S. LLEWELLYN & ASSOCIATES LIMITED  
CONSULTING ENGINEERS

March 6, 2019

**RE: 3598 Innes Road (D07-12-18-0132)**  
**Ottawa, ON**

Thank you for your comments in connection with the above noted project in regards to the review of the submitted engineering plans. We have had the opportunity to review your comments and offer the following response:

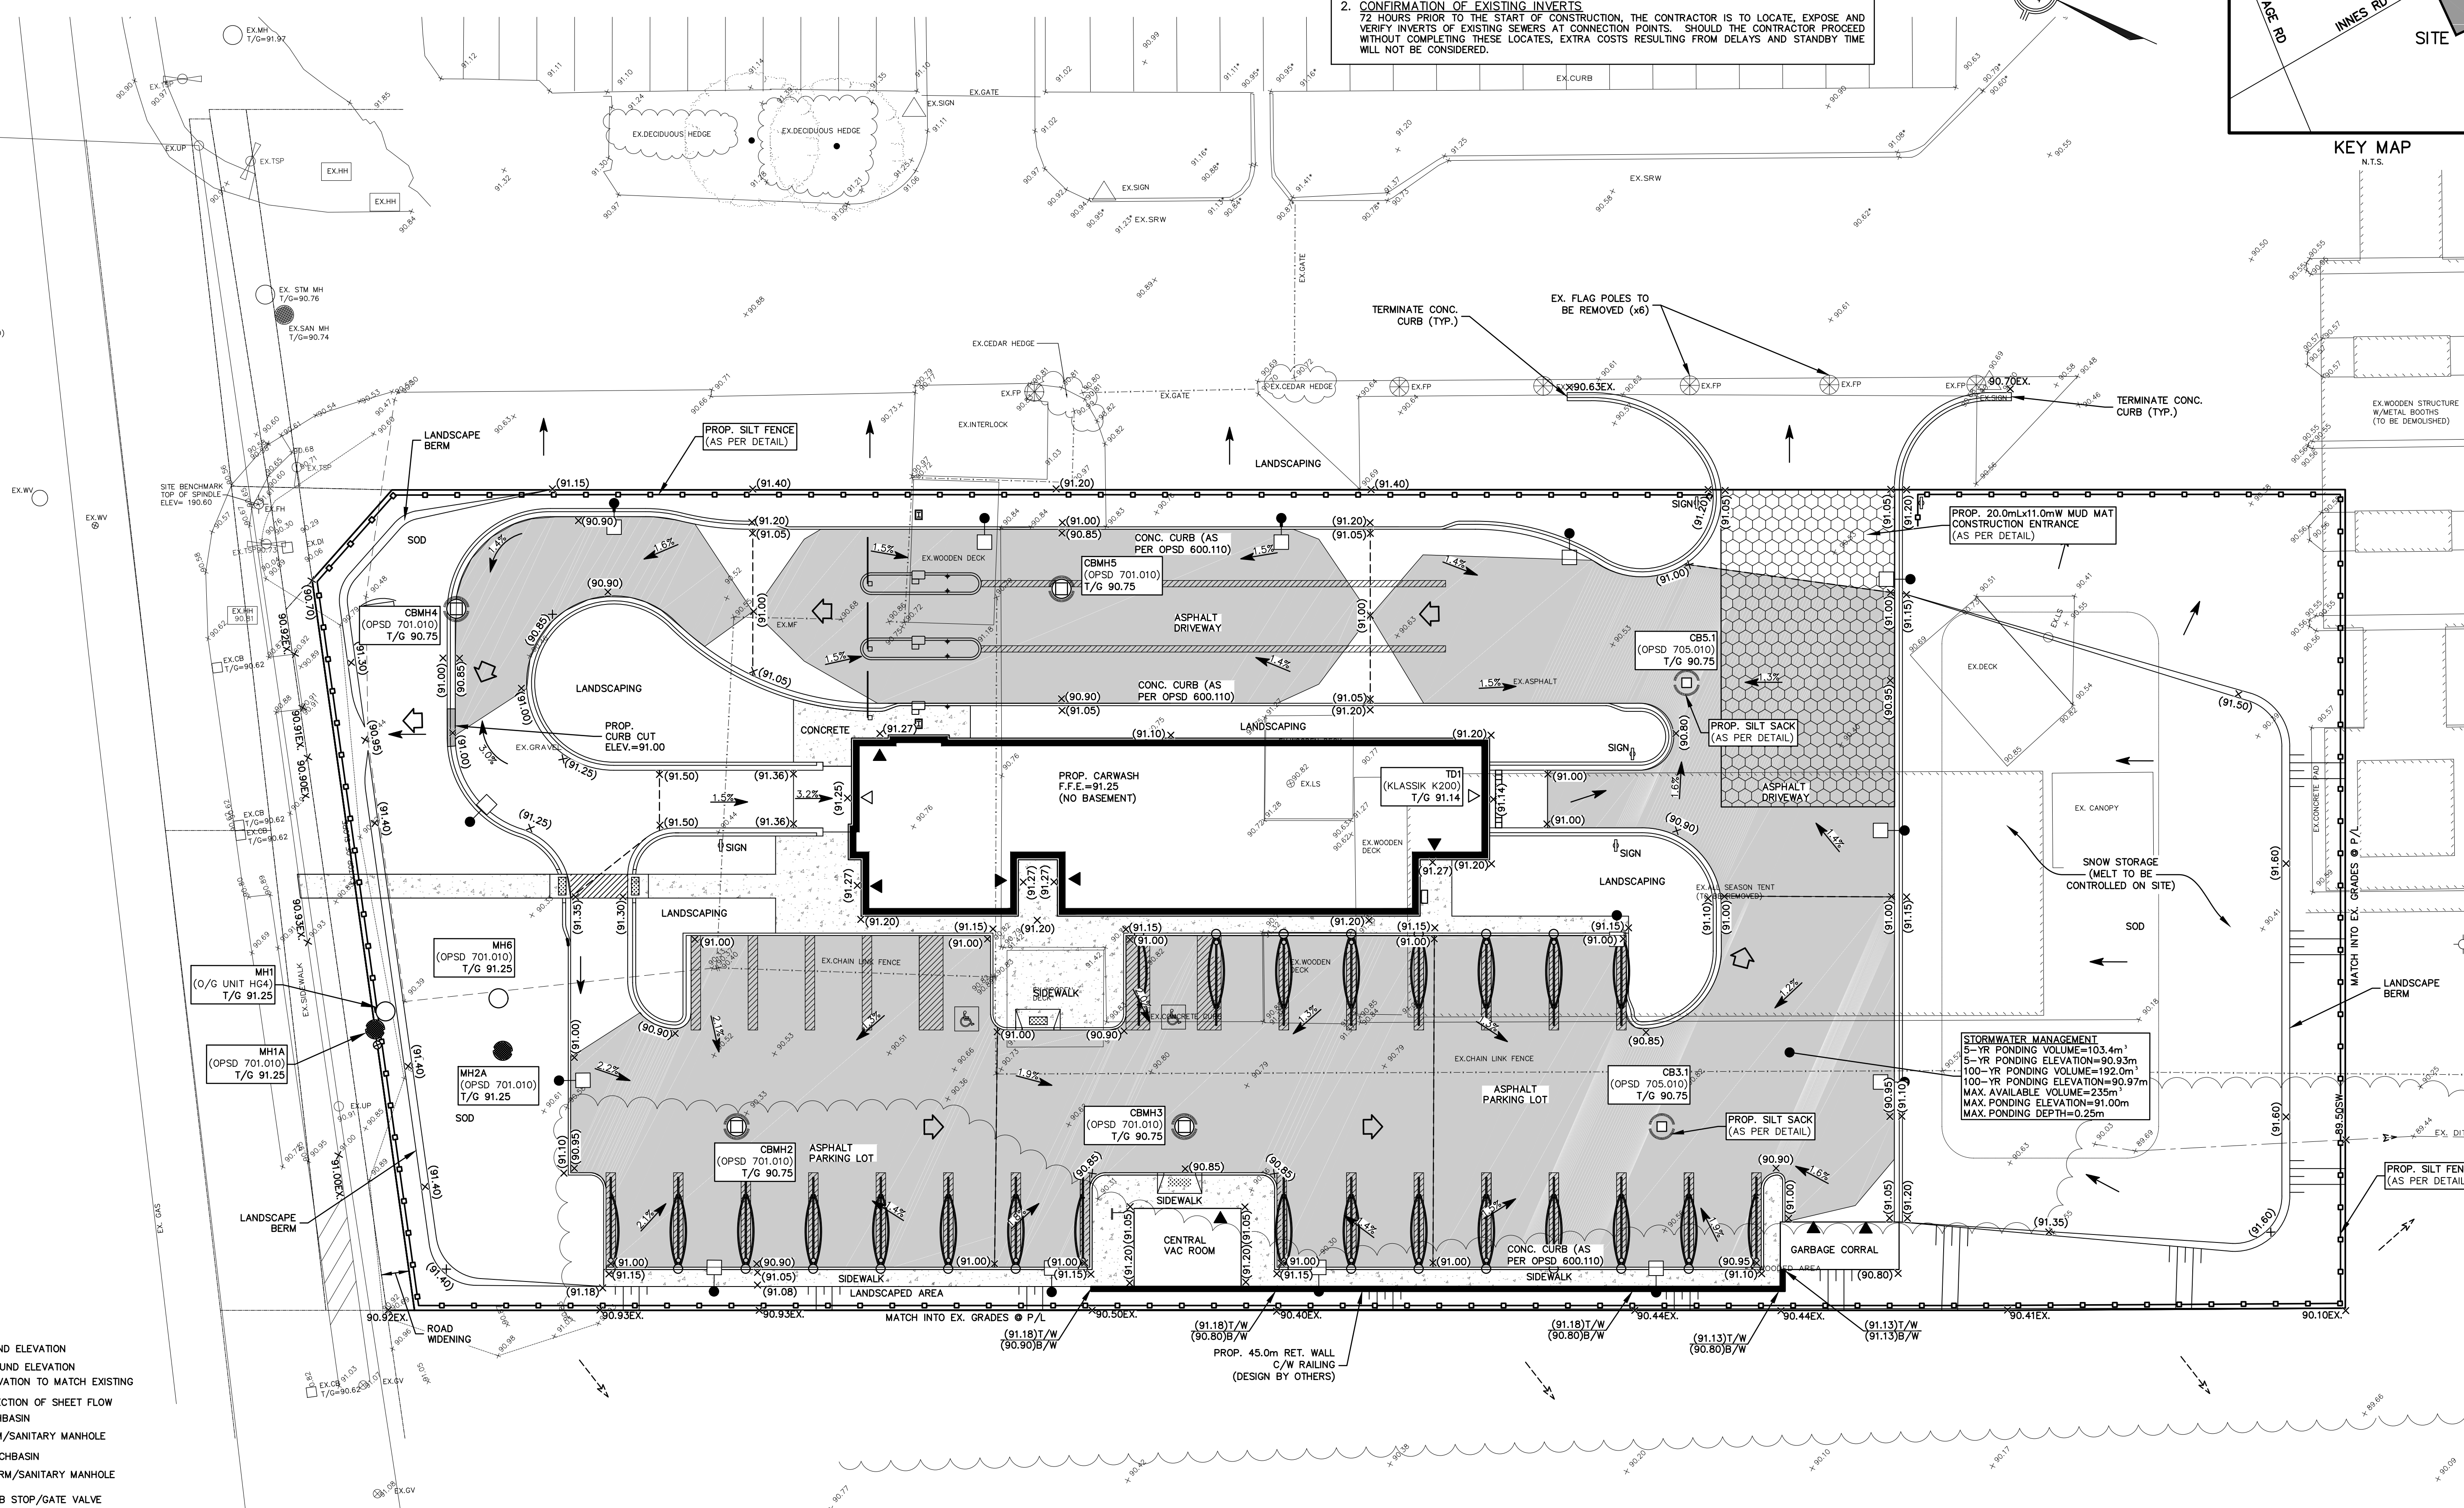
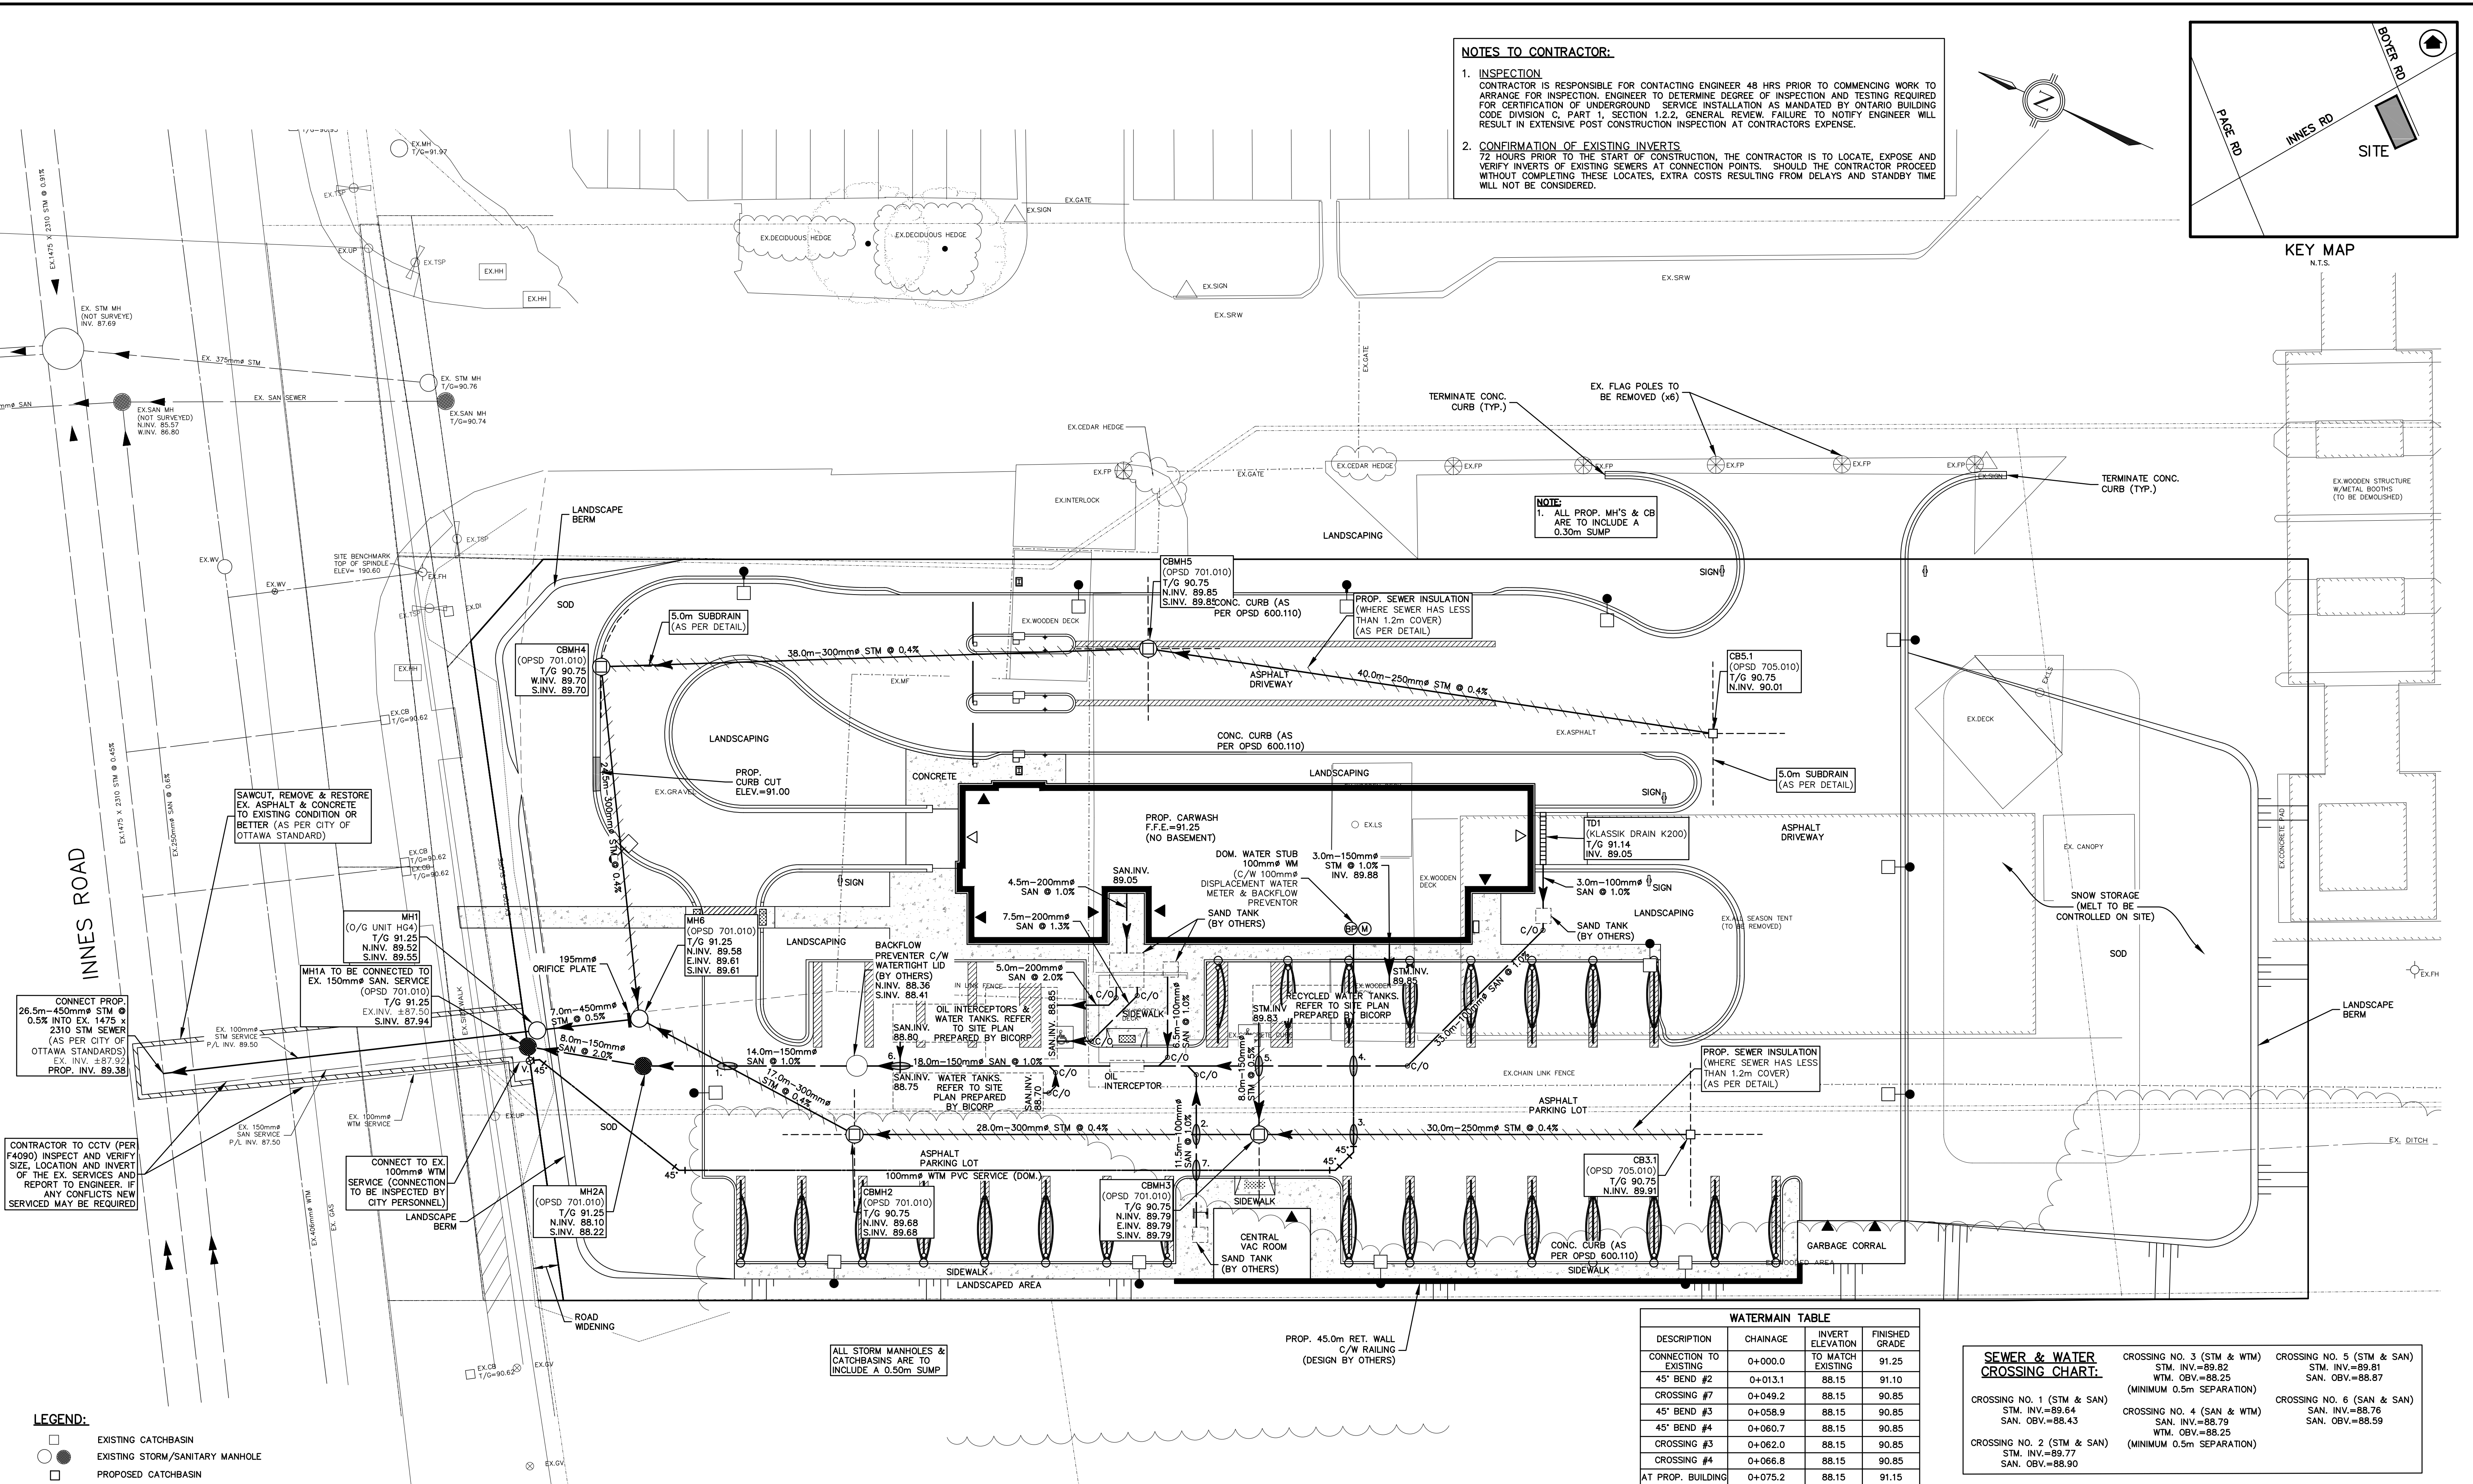
- A6. *Please note, according to City of Ottawa standards, quantity control is to be controlled by inlet control devices (ICD) rather than the existing orifice pipe sizes. Please re-design your SWM to include ICDs. (Refer to comment B1).*

2. *Change your connecting pipe to a 300mmØ.*

3. *Place a circle beside M & BP for Remote Readout (RR in the circle)*

9. *You need a clay seal for the storm pipe between MH 6 and MH1.*

**The proposed quantity control devices have been revised to an orifice plate. Please refer to the revised Functional Servicing & Stormwater Management Report along with the Site Servicing Plan for details.**

**The private storm service has been revised to 300mmØ as requested.**

**The remote readout symbol has been included on the servicing drawing.**

**The clay seal has been added to the drawings.**

DETAIL 1 ON-LINE ORIFICE DETAIL AT MH6  
SCALE: N.T.S.

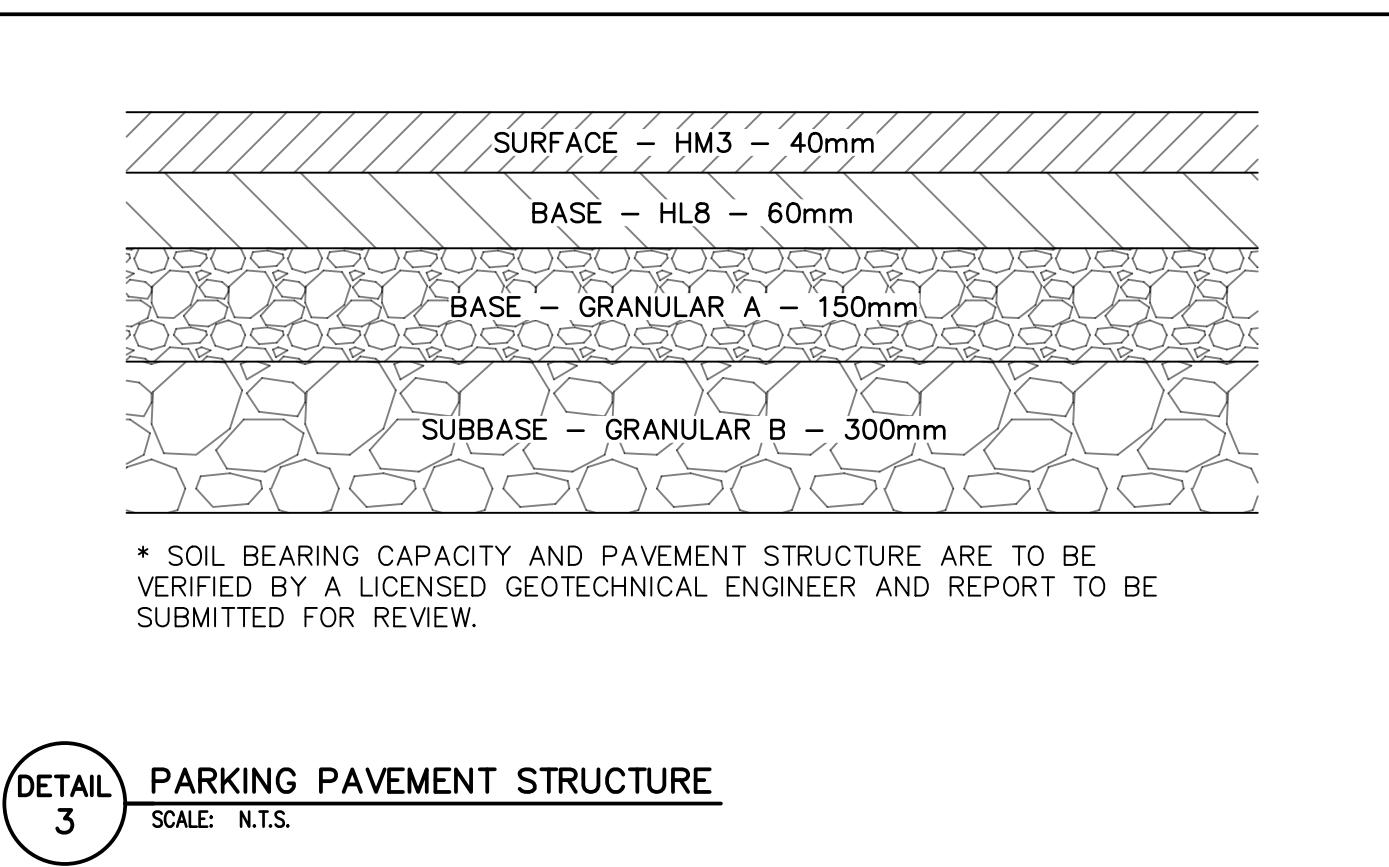
- A7. *Please add an ICD table with information including location, release rate, size, type, etc.*

**A Stage-Storage-Table has been added to the Note & Details Plan.**

DETAIL 6 SEWER PIPE INSULATION DETAIL  
SCALE: N.T.S.

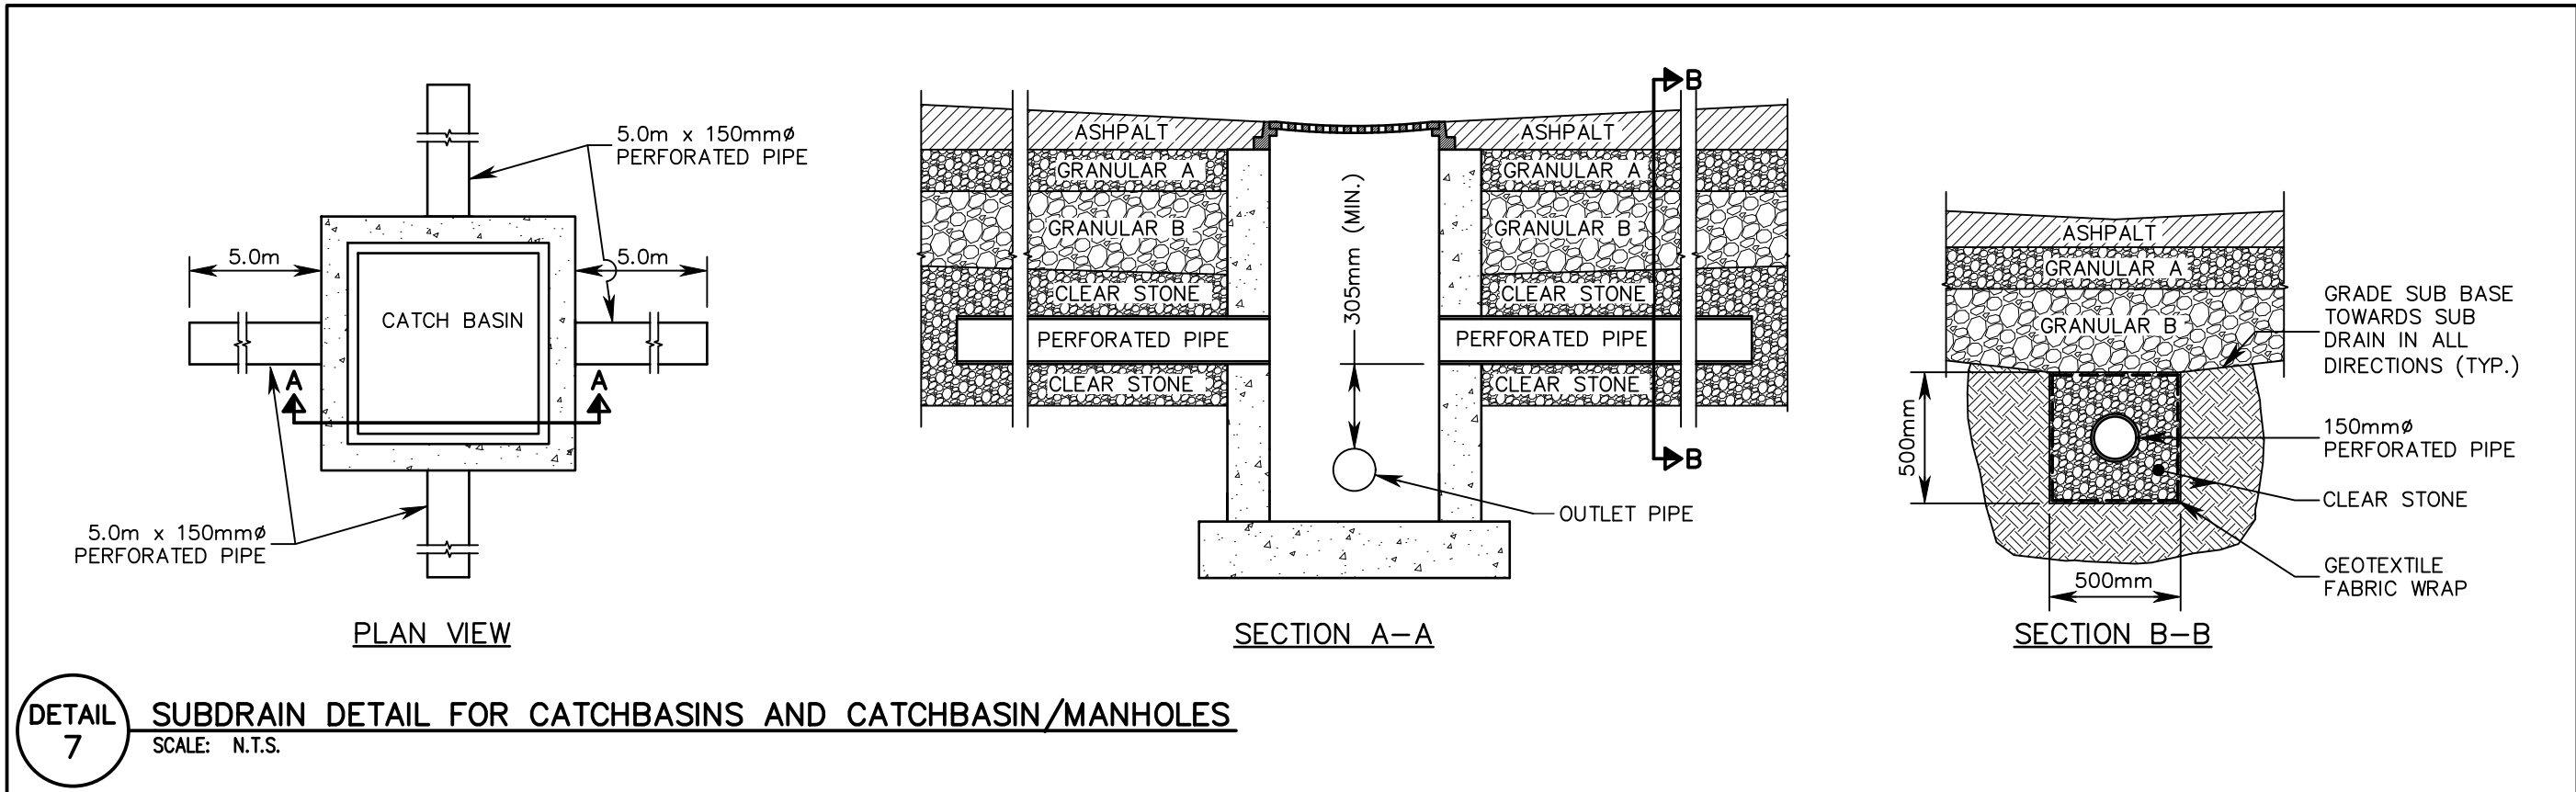
10. *The Geotechnical speaks to Site Services. Your Sewer notes (on the DWG) should mimic what they say....ie bedding materials and thickness. Your pipes are shallow and this should be increased to even more than what they propose.*

**Bedding materials and thicknesses are provided on the engineering Notes and Details plan and are in keeping with the geotechnical report. An insulation detail has also been provided.**
